Arun District Council
Arun Civic Centre
Maltravers Road
Littlehampton
West Sussex BN17 5LF
Planning & Building Control General Enquiries
Tel: (01903) 737756 Fax: (01903) 730442
Dx: 57406 Littlehampton
Minicom: 01903 732765
e-mail: planning@arun.gov.uk
website: www.arun.gov.uk/planning

Application No: LU/54/22/PL
Site Address: The Flintstone Centre East Street Littlehampton BN17 6AW
Description of works: Installation of 3000mm high welded mesh fencing and associated single leaf gate along a section of the northern boundary line and along the rear elevation, Ornamental fencing and associated gates to be installed, located adjacent to the existing southern side entrance to the building, as well as the installation of 3000mm high welded mesh fence encapsulating the existing boiler room to the rear of the building, demolition of existing side secondary entrance including existing ramped access and associated fittings. Repairs to the section of wall affected by the removal of the entrance. This application affects the character and appearance of the East Street Conservation Area and is in CIL Zone 4 (Zero Rated) as other development.

Thank you for your internet representation made on 2

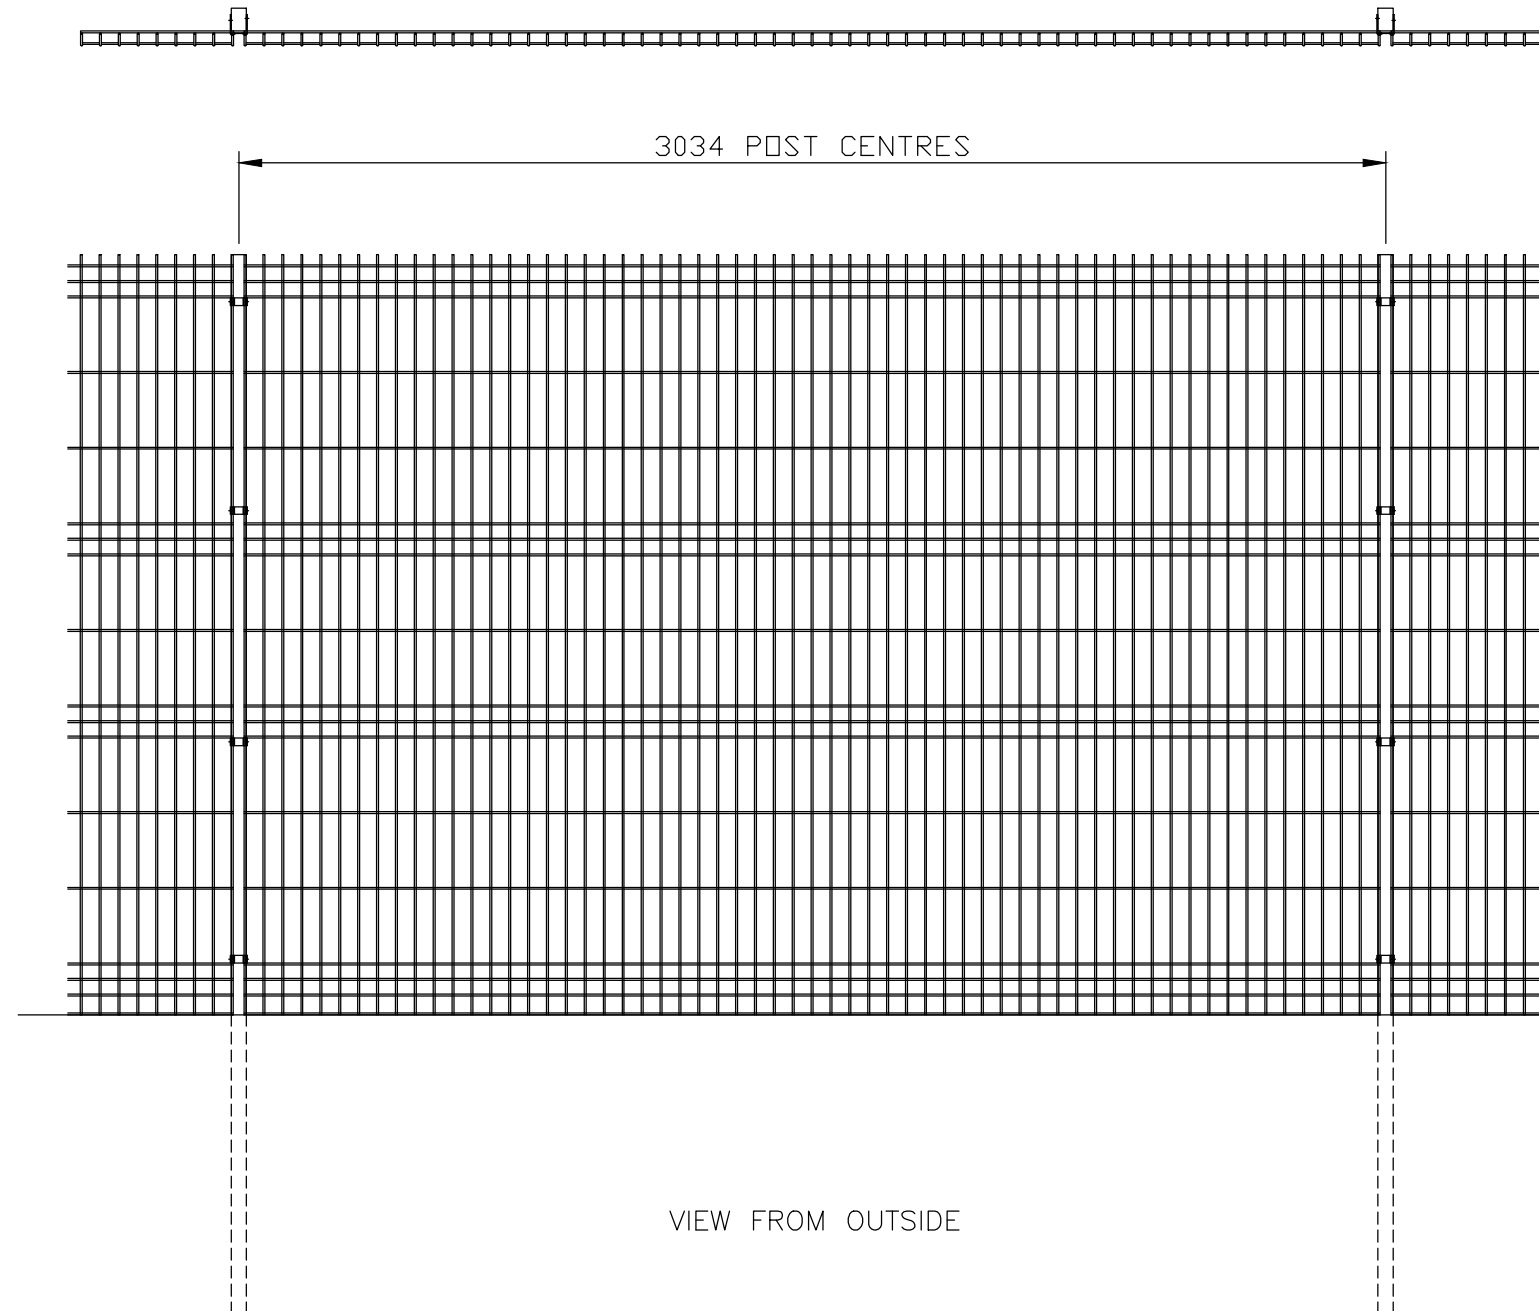
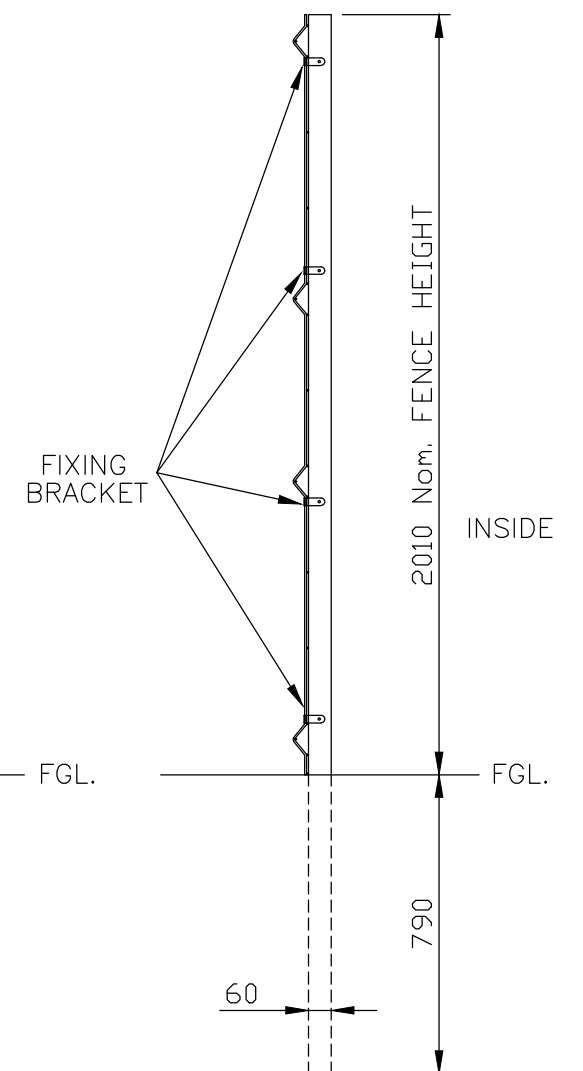
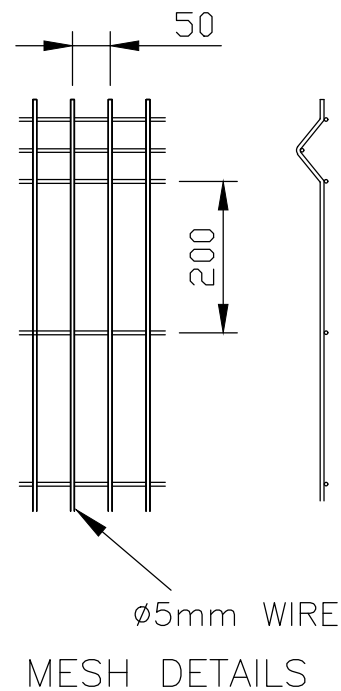
The proposed fence is welcomed as a measure to stop pupils from the school climbing over the wall to and from our development, The Old Dairy Farm, which sits behind the Flintstone Centre. However, the proposed Euroguard weld mesh fence is ugly and inappropriate, especially considering that this is a conservation area and that tight planning restrictions requiring an ornamental/heritage style gate and fencing were applied to the Old Dairy Farm development just to the rear.

I understand that the weld mesh fence is designed to be less climbable (to stop pupils leaving the school premises), but it should be noted that the proposed fence surrounds the car park area of the school, and not a playground. As such, the pupils should not really be allowed into this area due to multiple safety hazards.

The proposed Euroguard weld mesh fence is not in any way in keeping with the conservation area and would be erected within 5m of the heritage design and materials used for the gate and fence to the Old Dairy Farm.

This weld mesh fencing would be visually incongruous to the residents of The Old Dairy Farm. It would be erected within 10m of the front facade of numbers 1-5 The Old Dairy Farm, protruding above the existing flint wall, and also along the garden wall of number 8. The Euroguard weld mesh fencing looks more appropriate for use surrounding a prison or similar. Previous discussions with the Council stressed that the planning submission would include heritage/conservation style fencing to the rear, and not an ugly and inappropriate weld mesh fence.

Planning restrictions for The Old Dairy Farm required that all lamp columns be of a heritage design. Three of these lamp columns sit within 30cm of the proposed weld mesh fence. It seems highly inconsistent to apply different requirements within 30cm. It should be noted that the columns the developer actually installed were in breach of the planning restrictions and have been subject to a planning compliance investigation.
